**From:** Joseph Piccoli  
**To:** [Michelle Niles](#)  
**Subject:** RE: Wahoonga Adventist School (SSD 5535 MOD 2) - Notification of Modification - Ku-ring-gai Council submission  
**Date:** Wednesday, 9 January 2019 4:32:18 PM  
**Attachments:** [image001.jpg](#)  
[image002.png](#)  
[image003.gif](#)  
[image004.png](#)  
[image005.jpg](#)  
[image006.jpg](#)  
[image007.jpg](#)  
[image008.jpg](#)  
[image009.jpg](#)

Thank you for the opportunity to comment on the applicant's Response to Submission (RtS) on MOD 2.

fox valley road intersection  
 job number 1318.10  
 dwg. no. / issue & amendment  
 DA02A/1

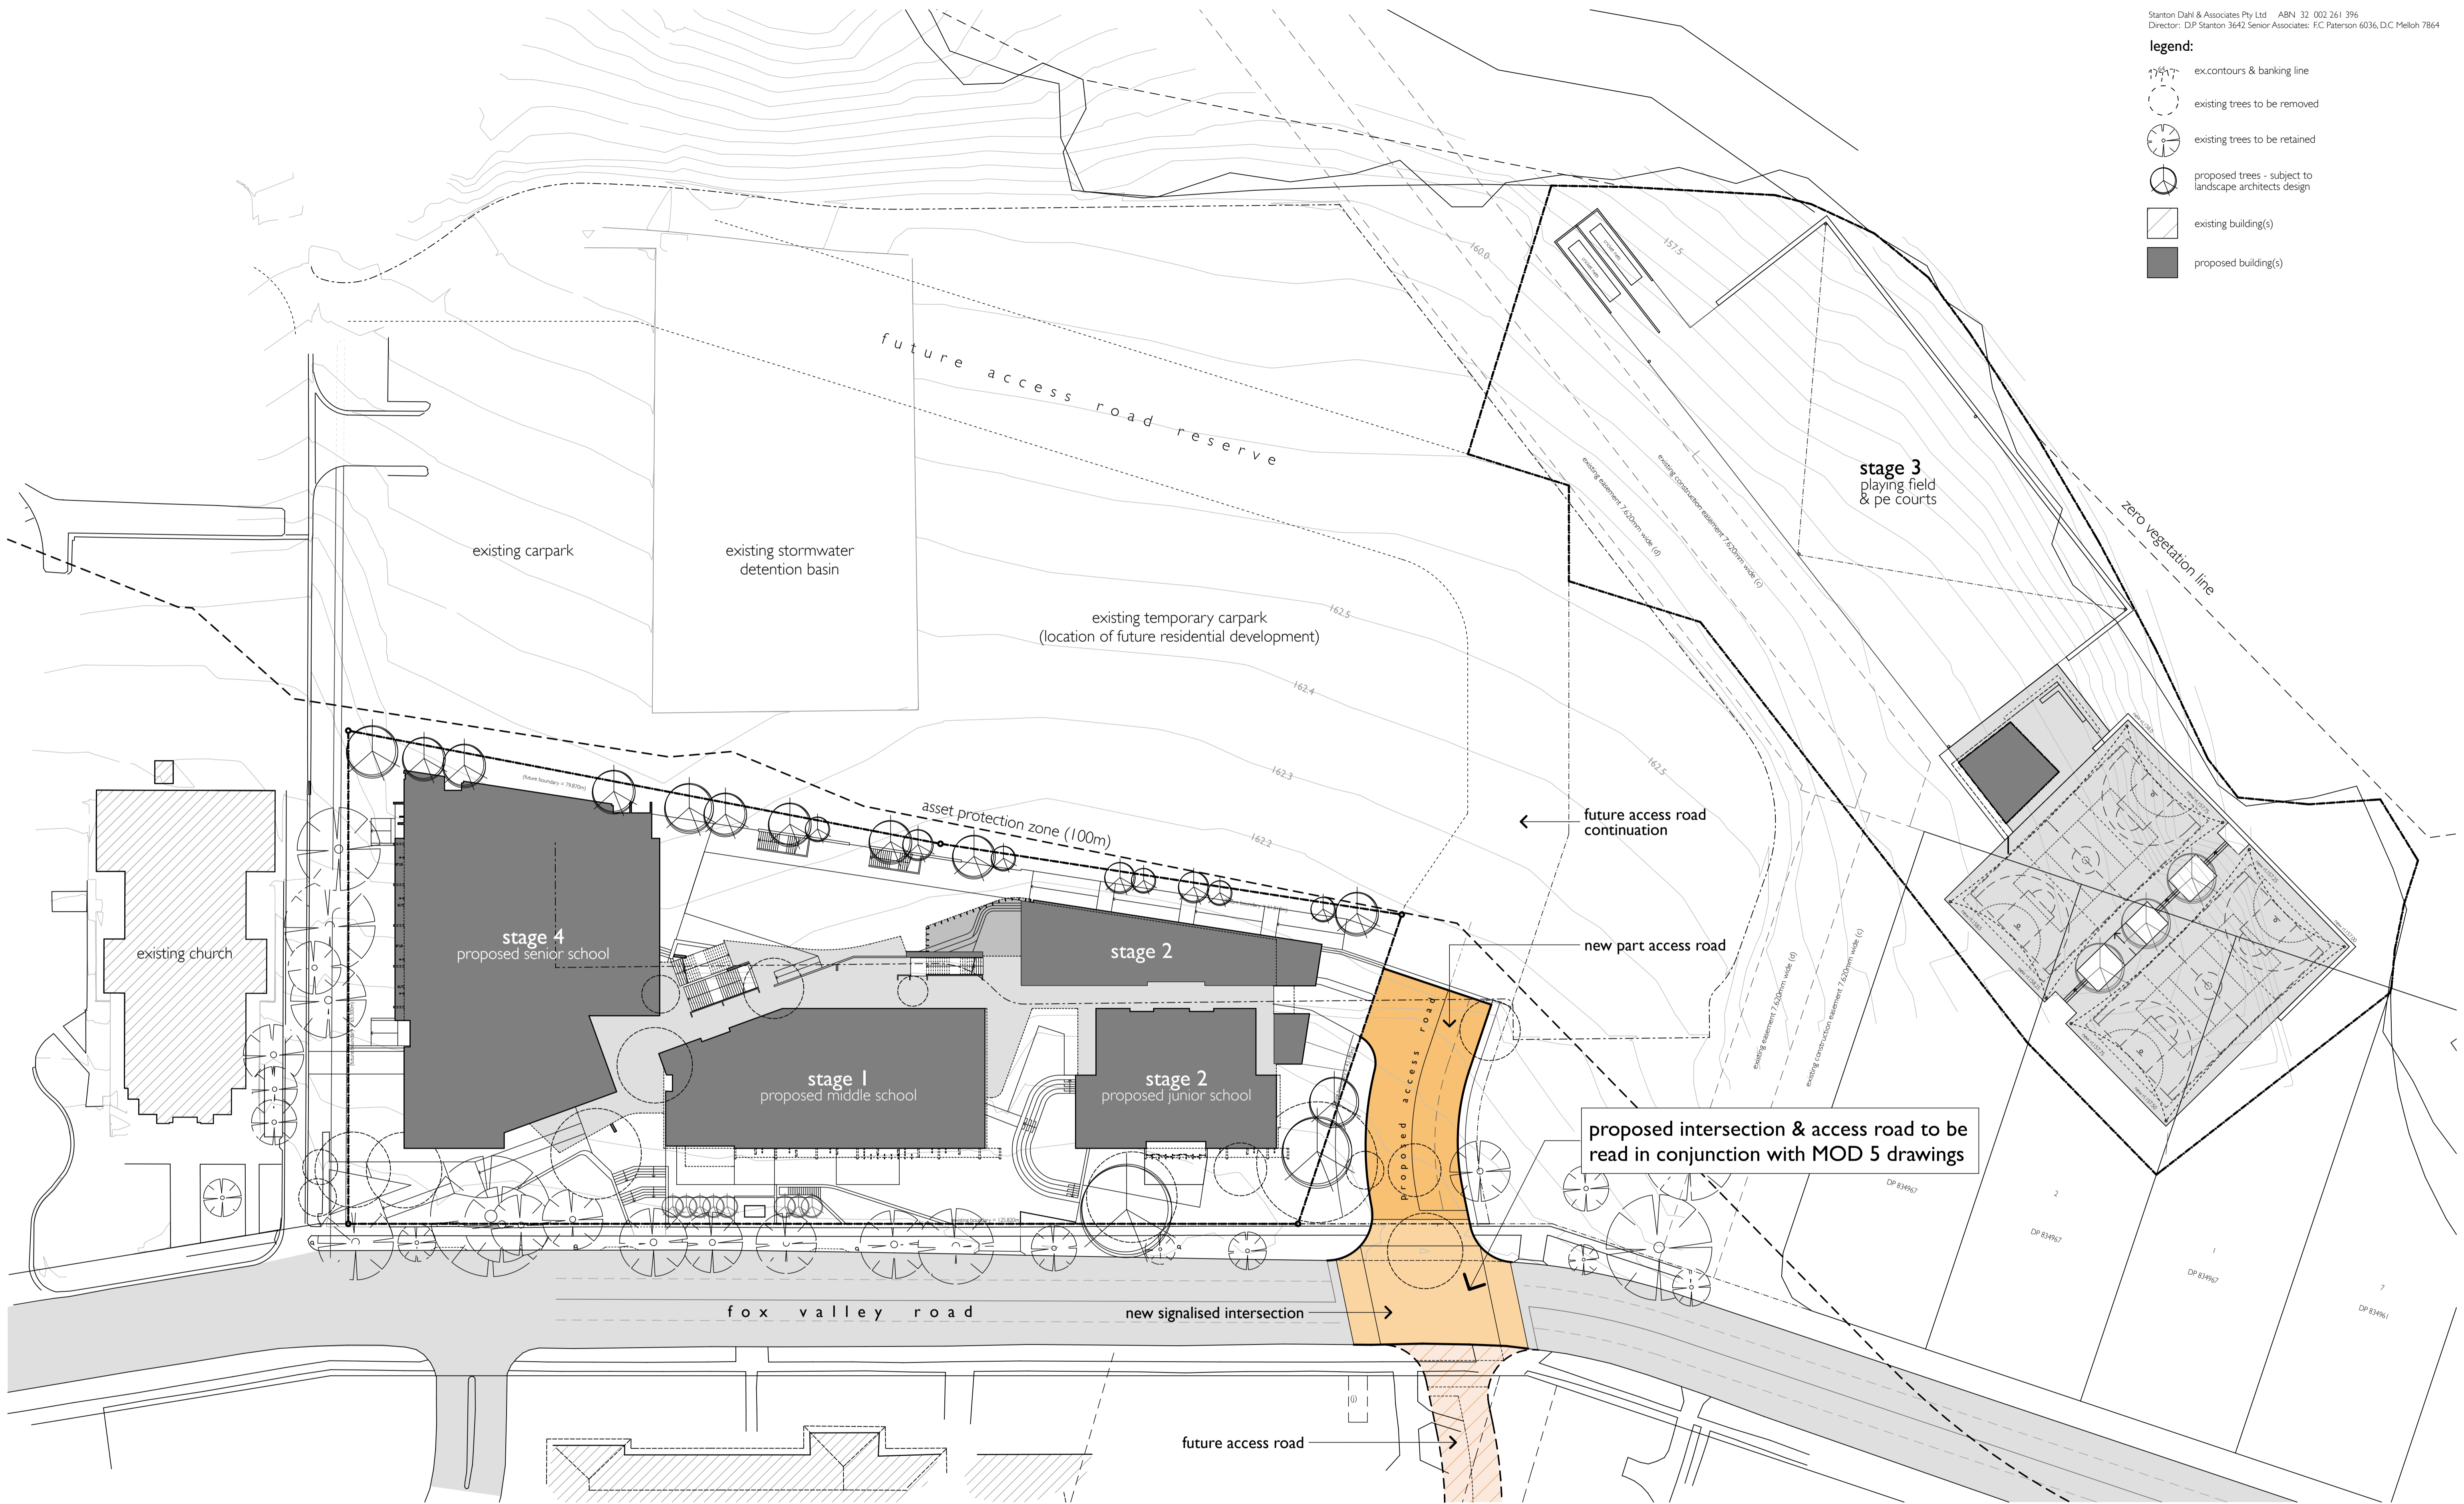
While Ku-ring-gai Council did not specifically comment on a timeframe for completion of the traffic signal works, there is no objection to incorporating a completion timeframe in the condition, and would support completion of the signalised intersection works within 12 months of occupation of Stage 3 development (as suggested by Transport for NSW).

In terms of the wording of a roundabout in the condition, it is worth mentioning that the one of the discussions between the applicant, RMS and Council around the configuration of the traffic signal arrangement concerns whether there is a need for dedicated right turn bays on Fox Valley Road (while maintaining 2 travel lanes in each direction) rather than shared through/right turn lanes as proposed by the applicant. The current traffic signal proposal by the applicant requires minor civil works, but comparatively substantial additional civil works (and potentially road reserve widening) would be required to accommodate 2 travel lanes in each direction and dedicated right turn bays.

If a roundabout were to be a fallback position, the space required to provide 2 entry/exit lanes in each direction on Fox Valley Road, as well as a central roundabout island, is likely to result in even more civil works and road reserve widening to accommodate it. Therefore a roundabout is likely to have higher costs and impacts than any traffic signal arrangement at this location and it is unclear why the applicant would be still considering raising this as a fallback option. At this location, a roundabout would also provide inferior pedestrian access and safety compared to a traffic signal controlled intersection
